Planning application No. 3/2024/0552

OBJECTION STATEMENT12th August 2024

Re:- Application Ref 3/2024/0552

Proposed change of use of ground floor unit (Use class E) and first floor flat (Use Class C3) to House in Multiple Occupation with up to eight rooms (Use Class Sui Generis) including removal of shop front and replacement with two ground floor windows and addition of new door and window to side elevation.

Client: Boutique Homes Ltd		
Project: Proposed Alterations 27-29 Bawdlands Clitheroe		
Dwg title: Proposed Rear Elevation		
Scale @ A3: 1:50	Date: 05.06.24	Drawn by: PD
Drawing no. 1569 - 1 - 12		Rev. B

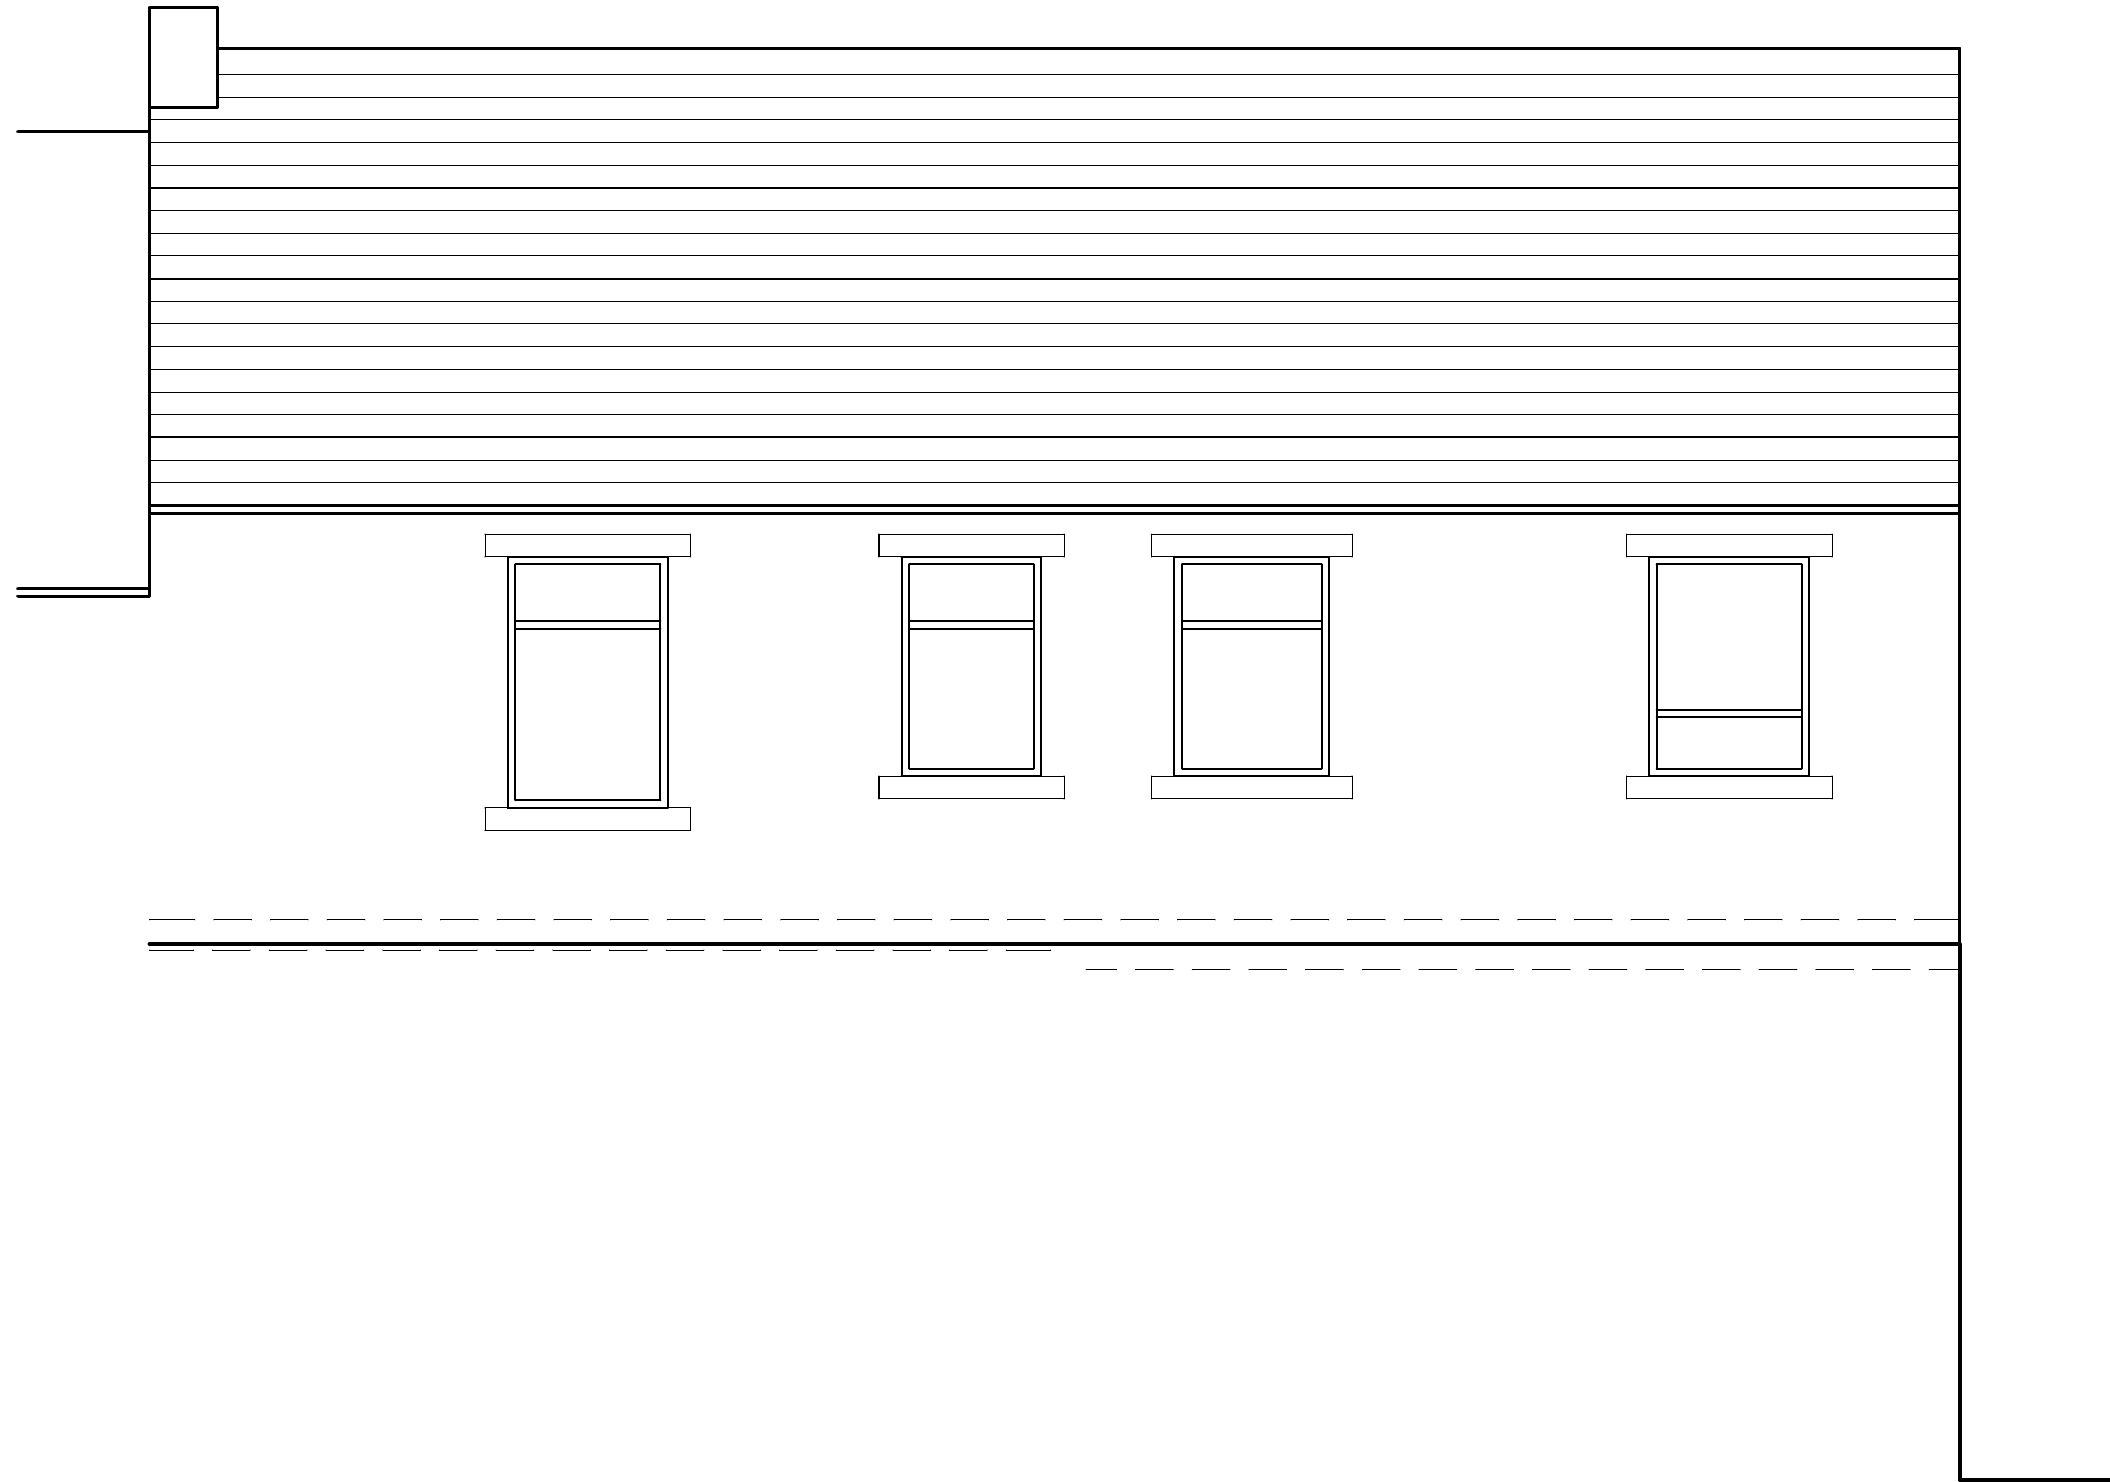
5.3: With regard to the windows to the rear elevation (Staircase, Units 6 & 7). Directly attached to the rear elevation is the Gym referred to in the previous planning applications. As this Gym is now under separate ownership and of a different Use Class (following the LPA approval of application Ref 3/2022/1080), these windows are directly on a boundary wall and there may be a requirement for these to have a designated level of fire resistance. This would require that the windows do not incorporate opening lights which would result in units 6 & 7 being devoid of any natural ventilation.

Client: Boutique Homes Ltd		
Project: Proposed Alterations 27-29 Bawdlands Clitheroe		
Dwg title: Proposed Side Elevation		
Scale @ A3: 1:50	Date: 05.06.24	Drawn by: PD
Drawing no. 1569 - 1 - 11		Rev. A

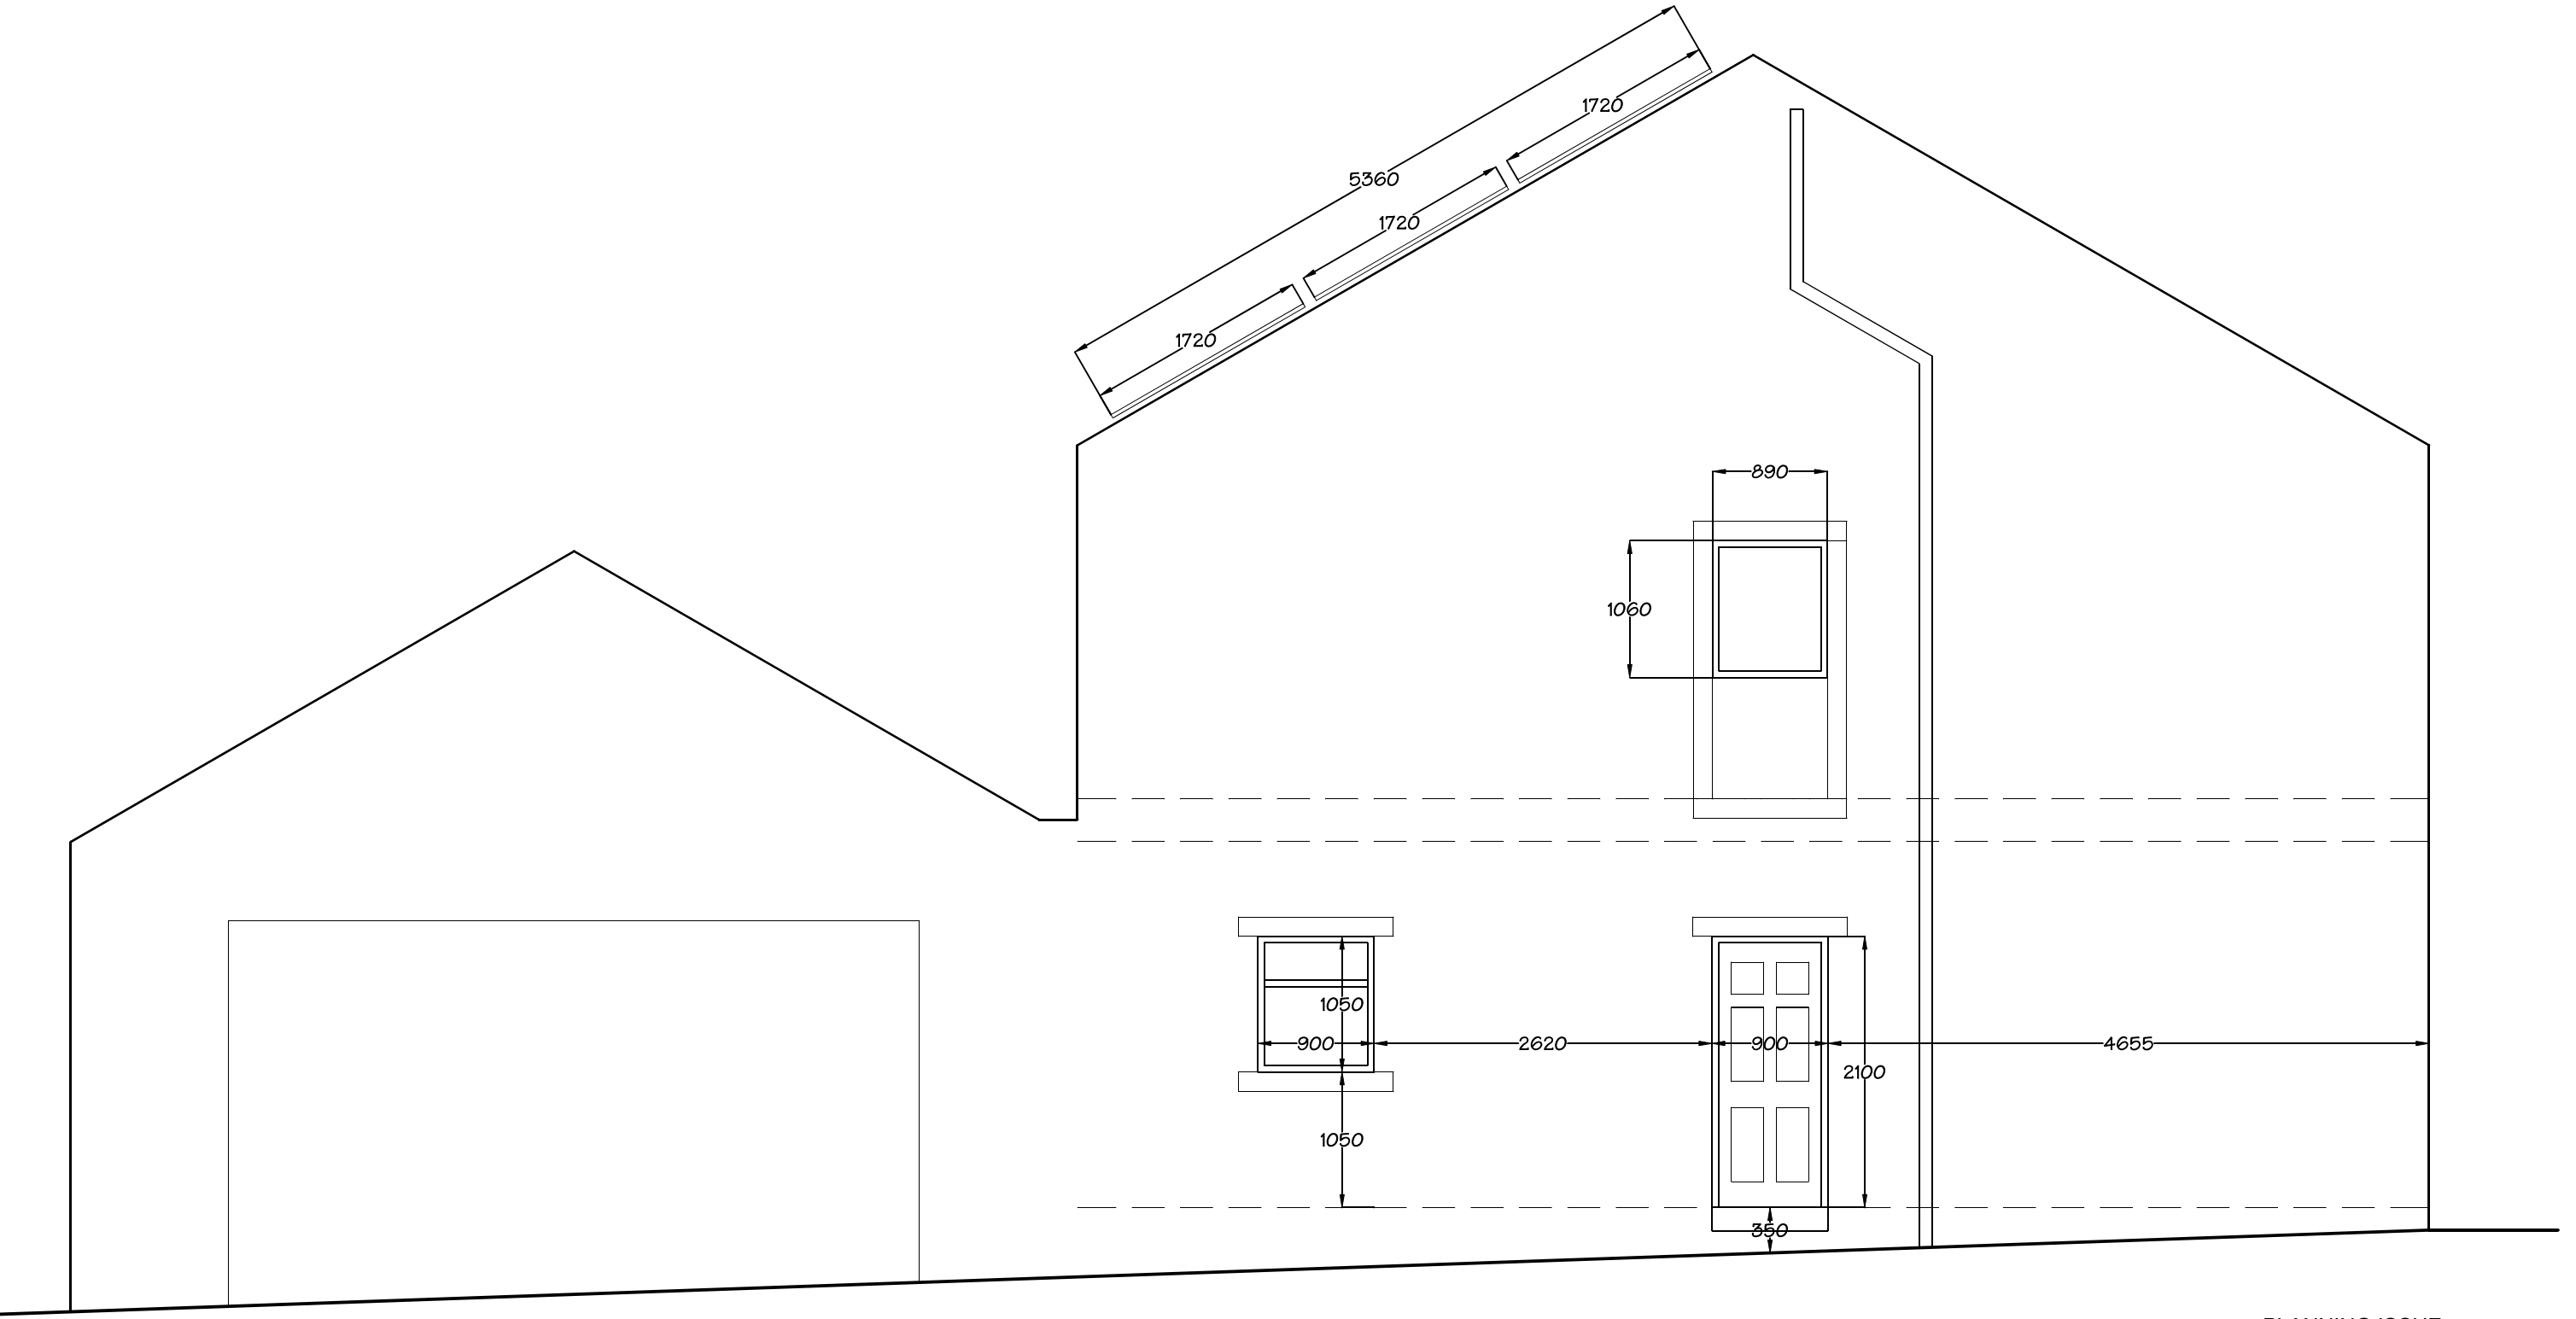
4.2: The external access to the Bin Store is proposed via the provision of a new doorway to the side elevation on Corporation Street. At the new door position there is a single step indicated on the Proposed Ground Floor Plan with 2 steps indicated on the Proposed Side Elevation, along with a dimension of 350mm from the pavement to the internal floor level. Given the painted plinth line along the side elevation this 350mm dimension would appear to be a rather conservative estimate, with the actual difference in levels being around 500mm at the worst case. A 500mm difference would necessitate the provision of a minimum of 3no steps to comply with Building Regulations requirements. Even considering 2no steps, these would have to be positioned within the curtilage of the building and not form an obstruction over the pavement, the knock on effect would be reduced space within the already very limited Bin Store.

6.2: The proposal requires a number of terminals in external walls to accommodate mechanical ventilation, which are not indicated on the proposed Elevations, there would also be some requirement to ventilate the Bin Store. It is also unclear as to if the En-suite / Kitchenette wastes, particularly to the units bounding Corporation Street are proposed to be run internally or externally. Should it be intended to run the wastes externally this would have a serious detrimental impact of the street scene and therefore visual amenity.
